From: Jim Henn
Sent: 19 March 2012 14:07
To: Planningecons
Subject: RE: Planning Consultation on: FG/6/12/
 Dear Anita,

APPLICATION NO:	FG/6/12/
Registered:	30th January 2012
Site Address:	The Old Barn Ferringham Lane Ferring BN12 5LL
Grid Reference:	509368 102597
Description of Works:	Change of use of the Old Barn, Annexe building & warehouse from (A1) retail to 2 no. 3 bed residential dwellings (C3 dwelling houses)

The Annex - Proposed Ground Floor

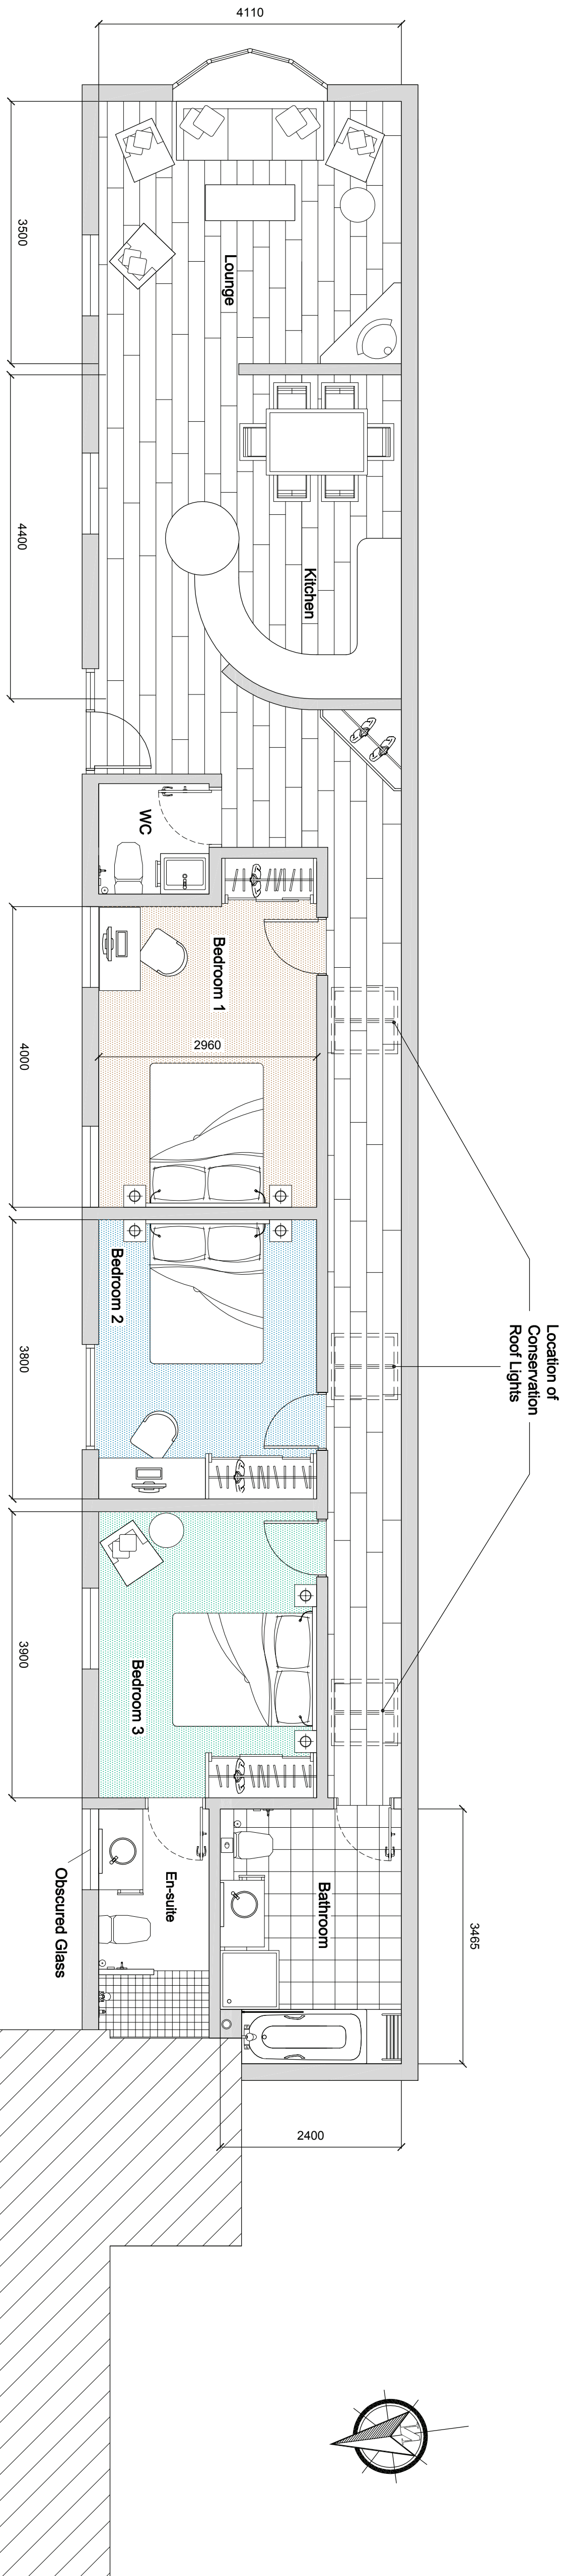
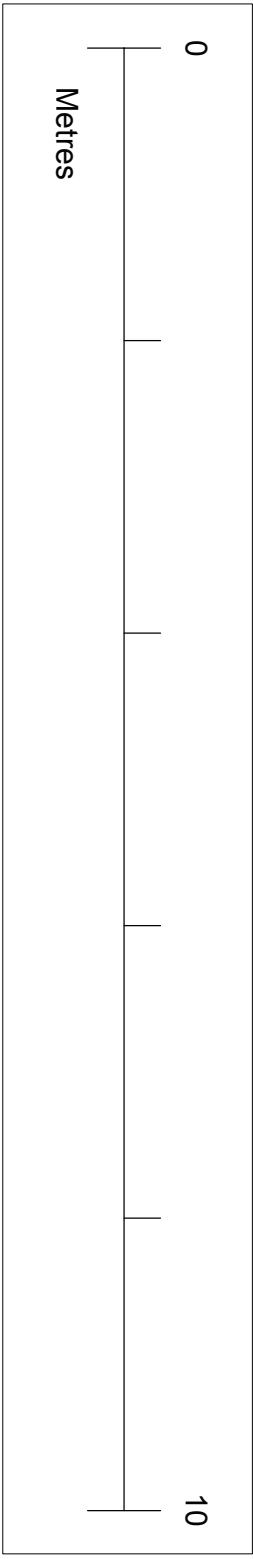
- A structural appraisal of the existing building with respect to suitability for conversion purposes would be required under the Building Regulation. Guidance for such 'change of use' developments is given in the following documents :
 1. BRE Digest 366 ; Structural Appraisal of Existing Buildings for Change of Use
 2. The Institution of Structural Engineers Report 'Appraisal of Existing Structures, 1996'
- Provisionally, it would appear that inadequate Means of Escape have been considered in the following locations:
 1. Bedrooms 1 - 3 of the 'Annex Building'.
 2. The Study, Dining Room and Bedrooms 1-3 of the 'Main Barn'
